Gurinder Walia - 9710 0362
File Ref: DN09/0001

9 April 2013

Proposal: Section 75W referral to modify approved development at Kareena Private Hospital (your ref: MP08_0169 MOD 1)
Property: 86 Kareena Road Caringbah

Proposed Ground Floor Plan

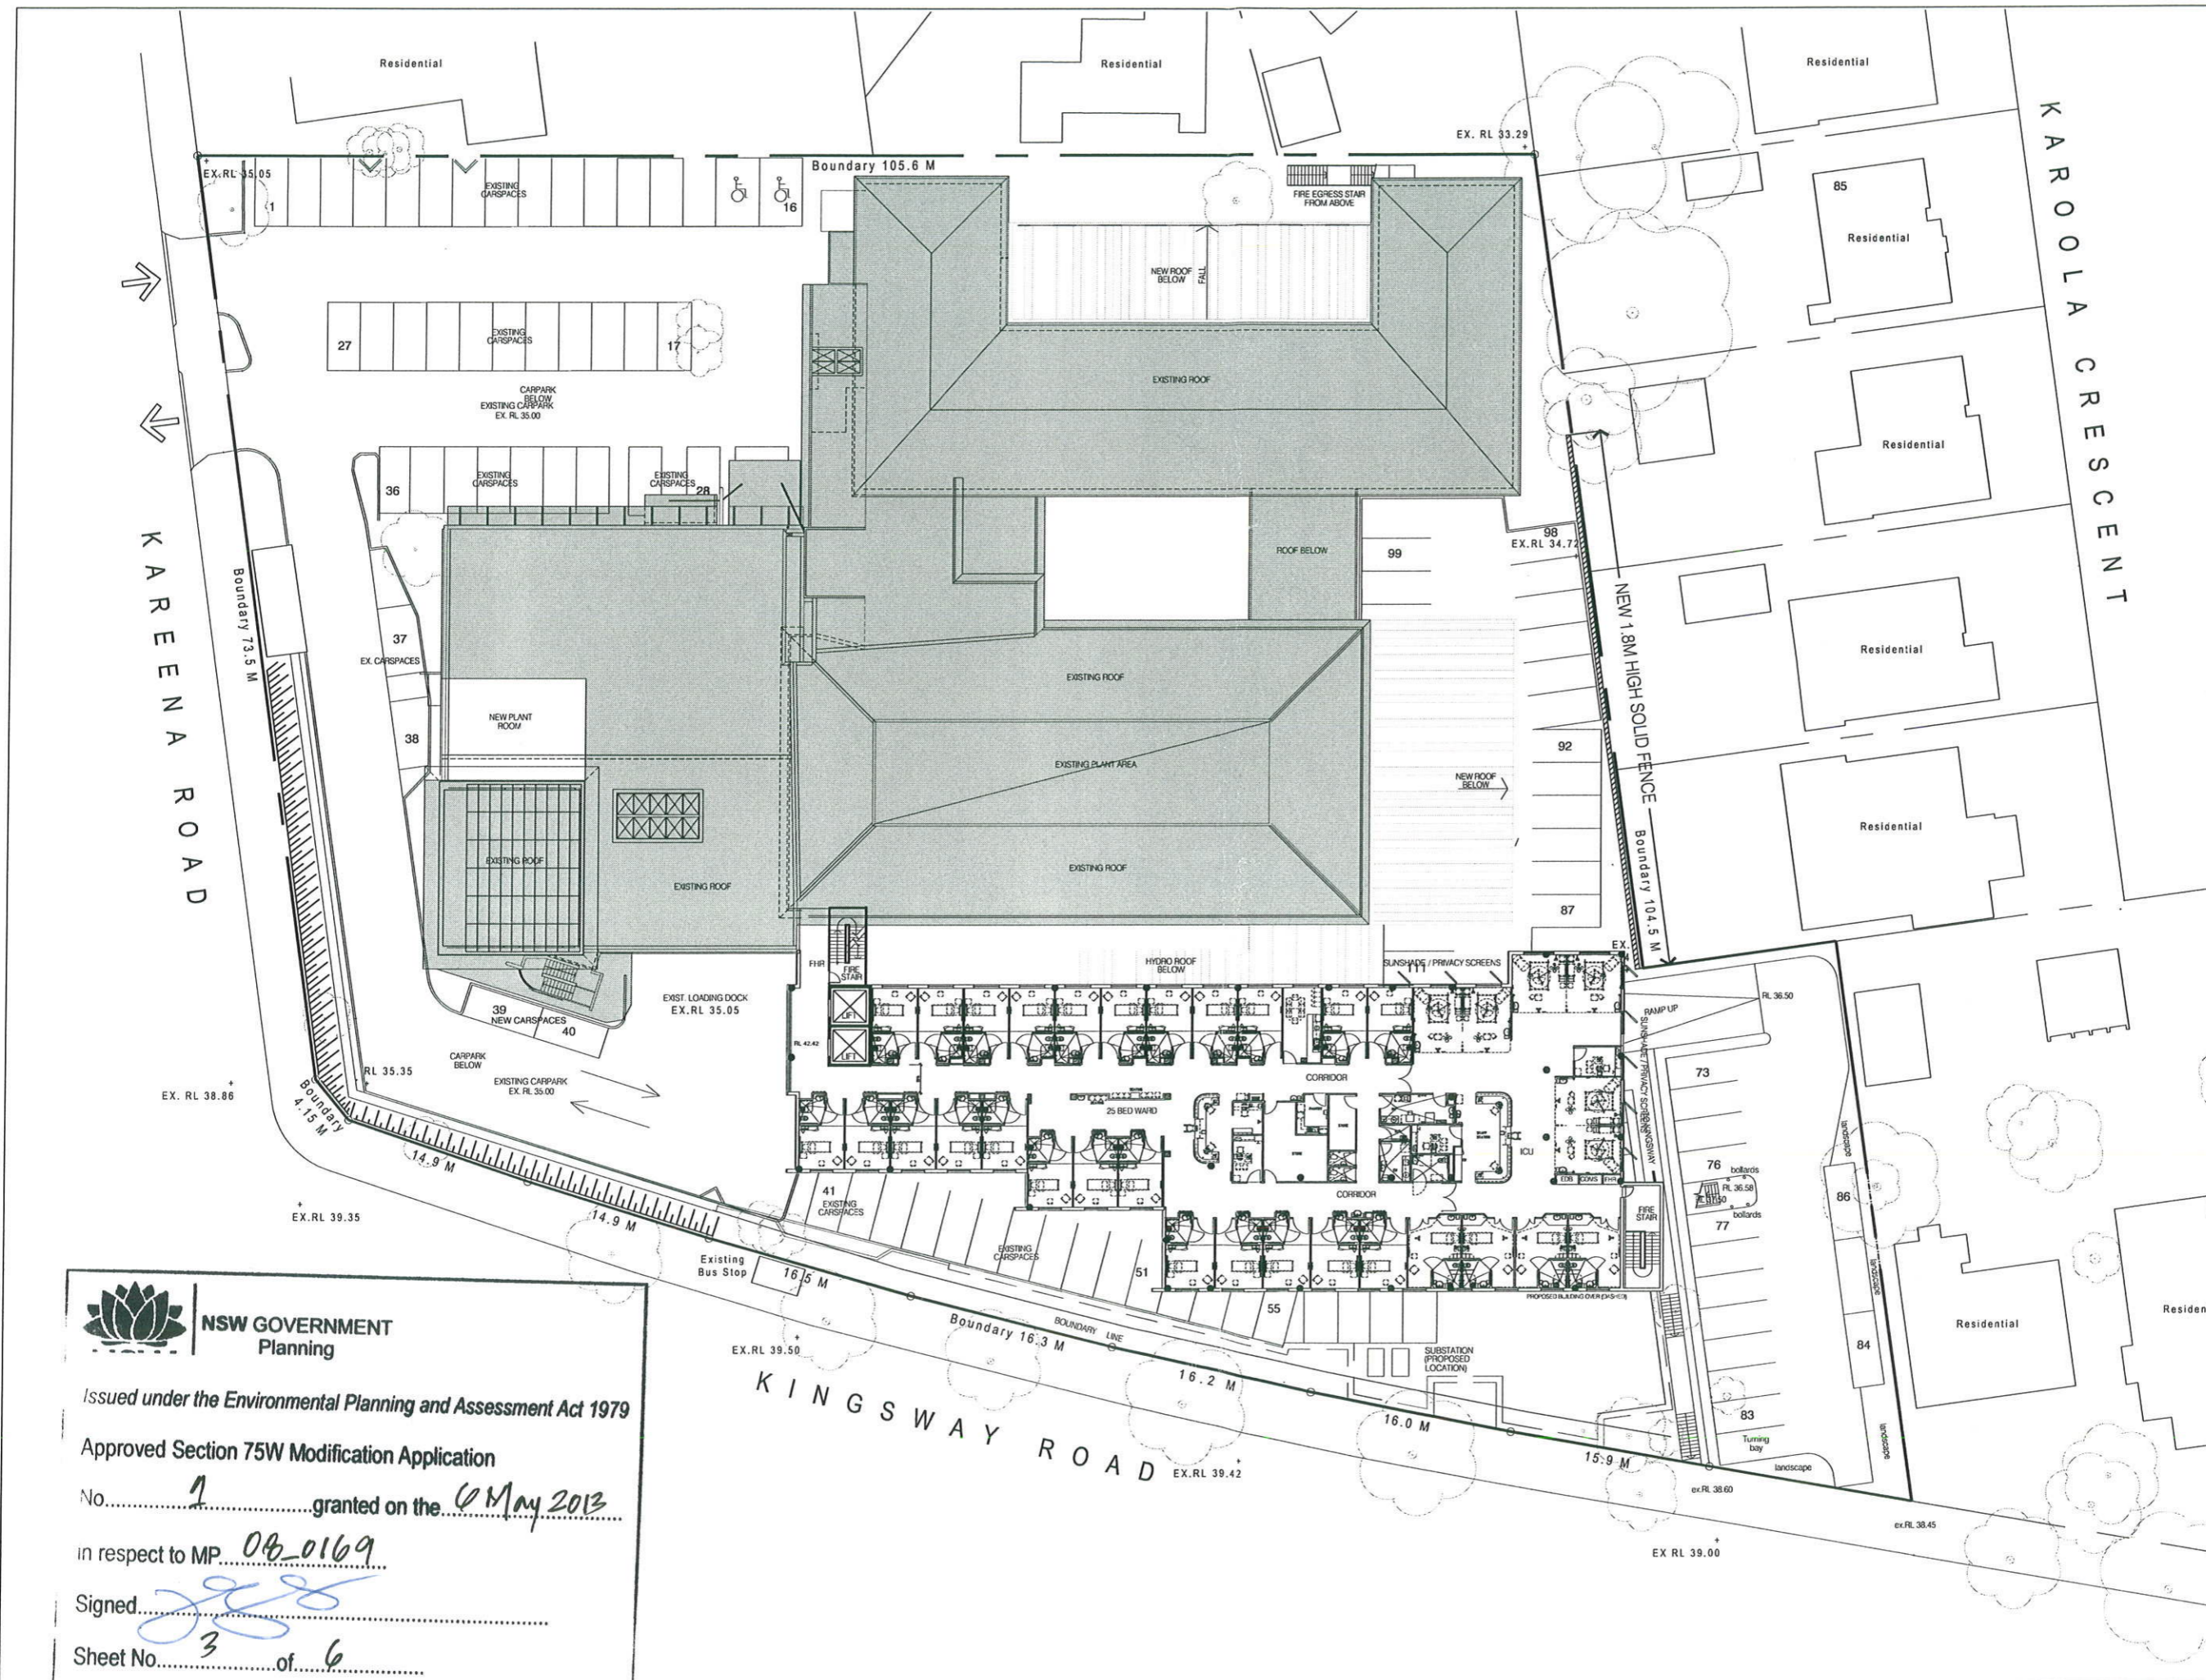
The application proposes an easterly extension of approximately 5.5m, in addition to the extension already approved. The extension is shown to be supported by columns which appear to be located within the aisle or carspaces immediately below, thus affecting vehicular accessibility and use of the car park. In addition, the plans seem to indicate a very low head clearance as a result of beams and/or RFC panels.

The method of structural support must be reconsidered so as to ensure the extension does not impact upon parking and manoeuvring. The head clearances required by

AS2890, including those required to facilitate parking for persons with a disability, must be observed.

ELEVATION - EAST

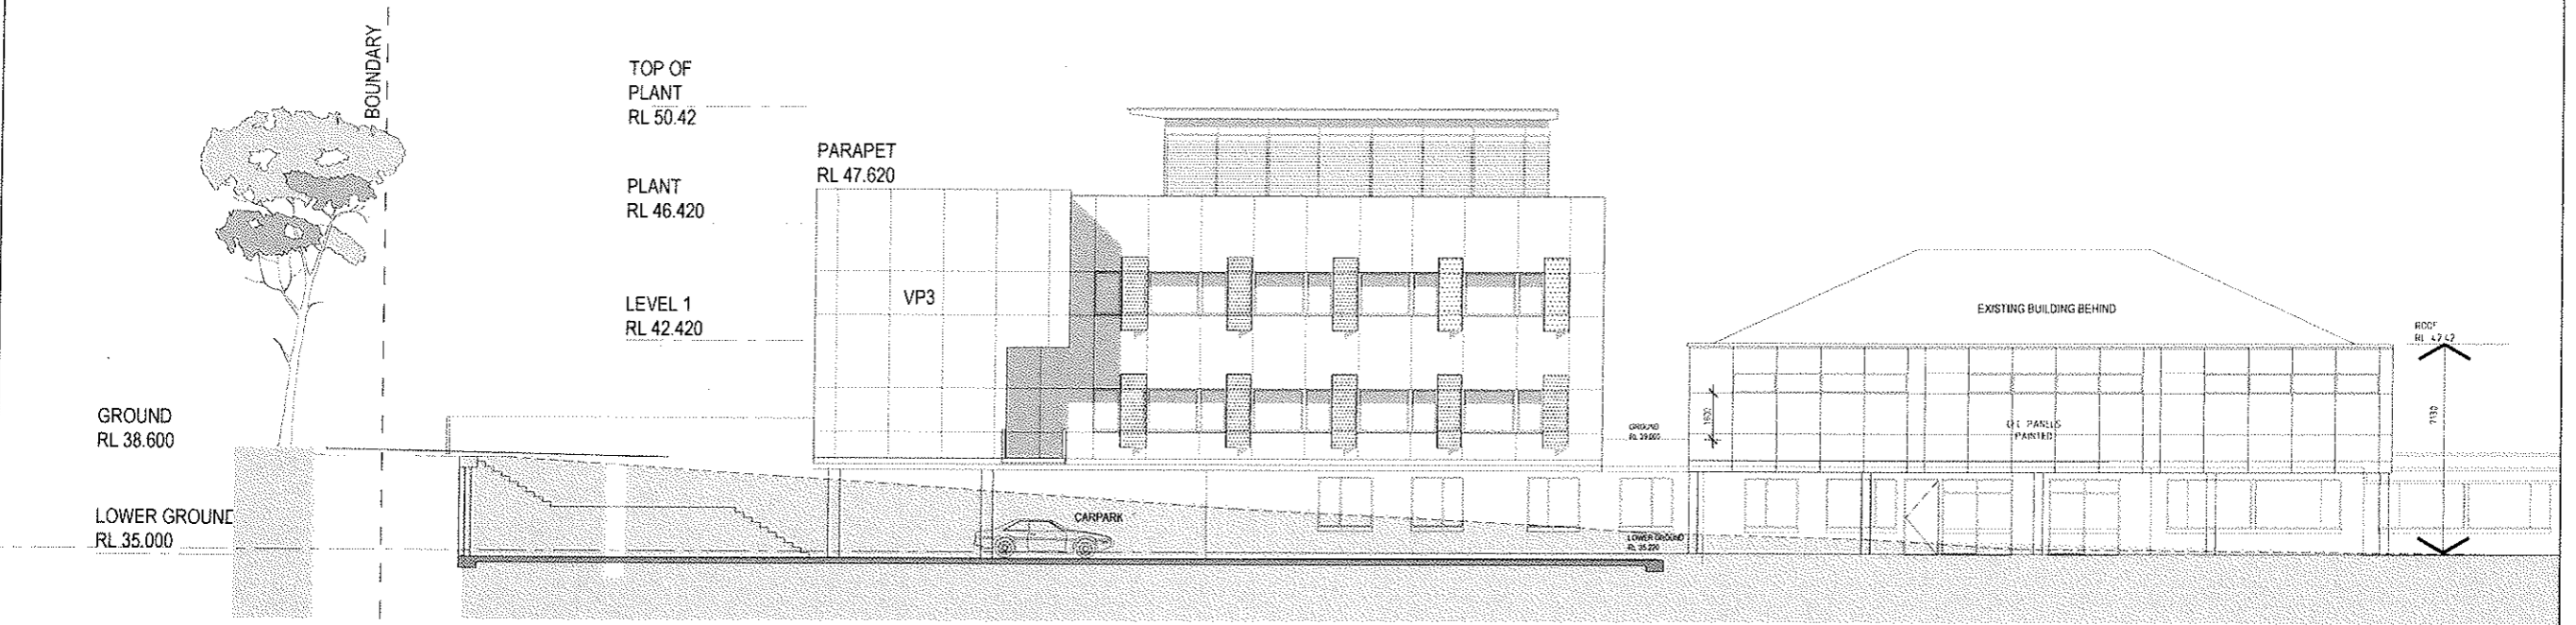
The eastern elevation appears to show windows within RFC wall panels. The window sill height and type of glazing is unclear. To minimise privacy impacts upon the adjacent rear yards to the east, Council recommends the use of highlight windows or opaque glazing or external louvres set at an angle/direction to only permit outlook away from residential rear yards.
